## REQUEST

Current Zoning: R-3 (single family residential)  
Proposed Zoning: R-8MF(CD) (multi-family residential, conditional)

## SUMMARY OF PETITION

The petition proposes to allow a mix of ~~quadrplexes and duplex~~ containing up to 19 **attached multi-family residential** units on a parcel currently developed with a single family home and a barn.

RZ-2

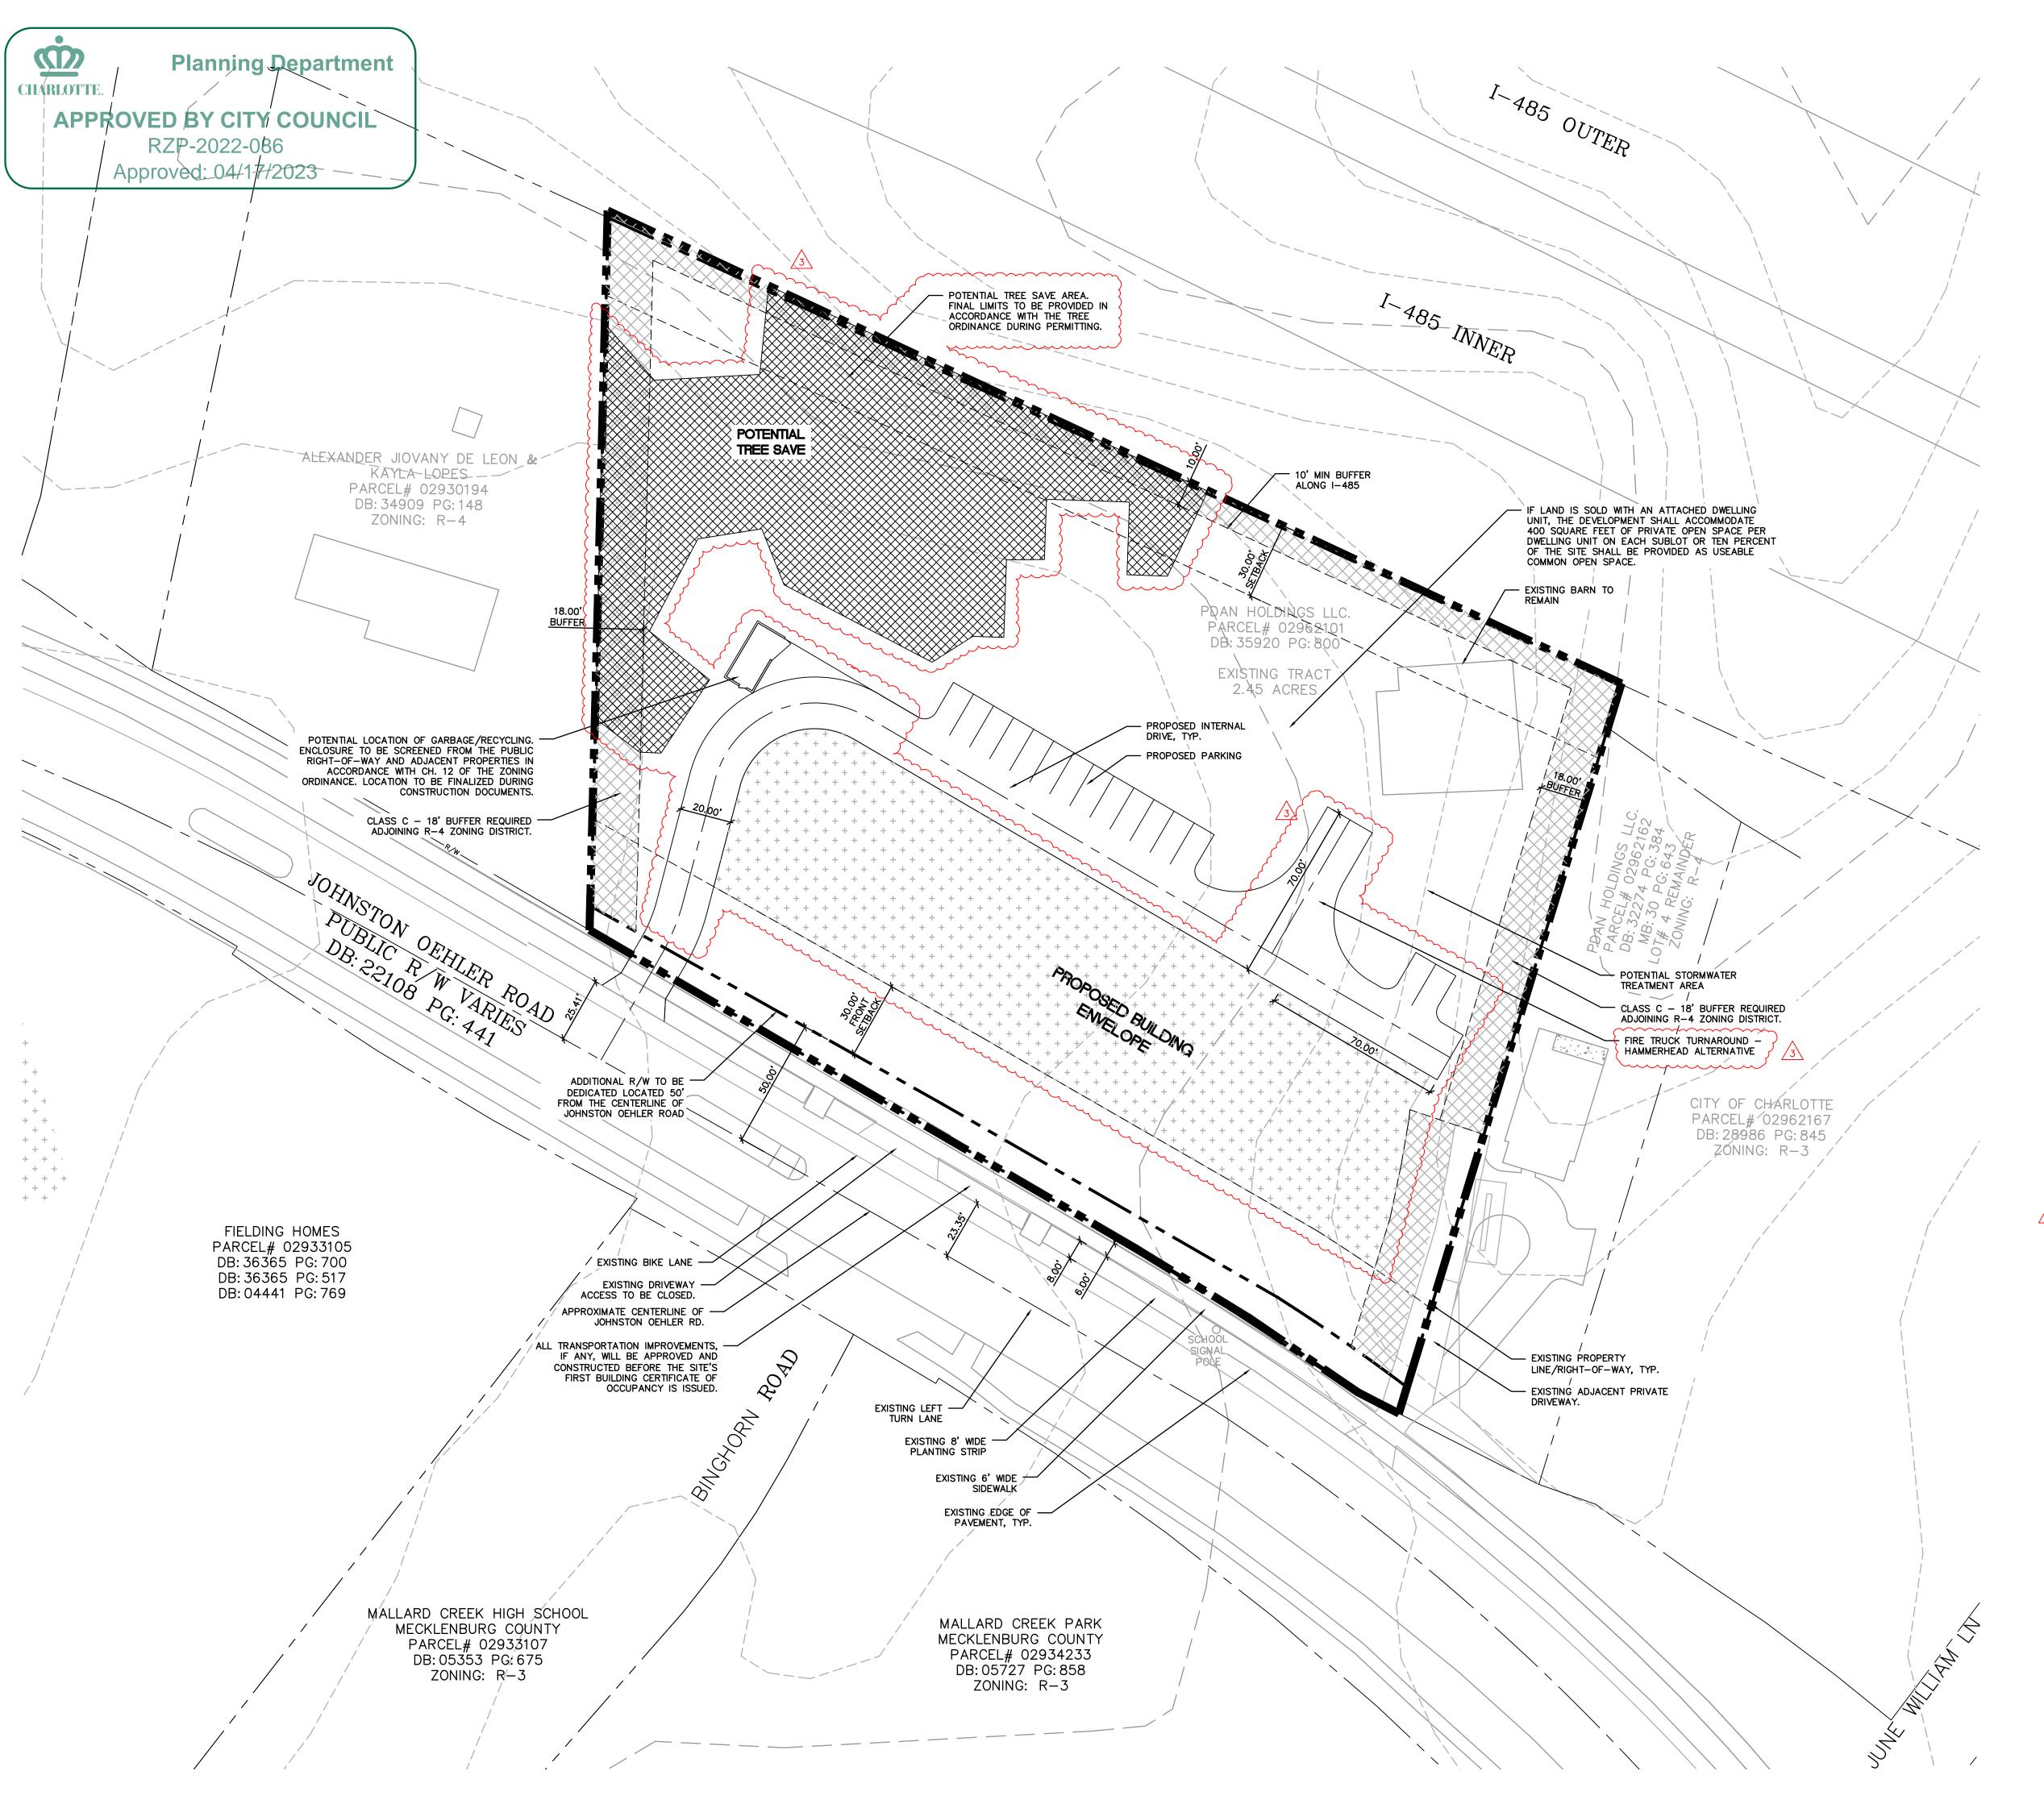
1. ~~Part of what is shown would not qualify as protected tree save. This will either need to be adjusted to protect existing trees and/or additional tree save would be required.~~ **Update:** Petitioner must show acceptable tree save on rezoning plan. Replanted tree save is not an available option. **Addressed**

4. ~~Increase setback to 30 feet along Johnston Oehler Road and along I-485.~~
5. ~~Connect buildings to sidewalk system along Johnston Oehler Road.~~
6. ~~Illustrate parking on site plan.~~
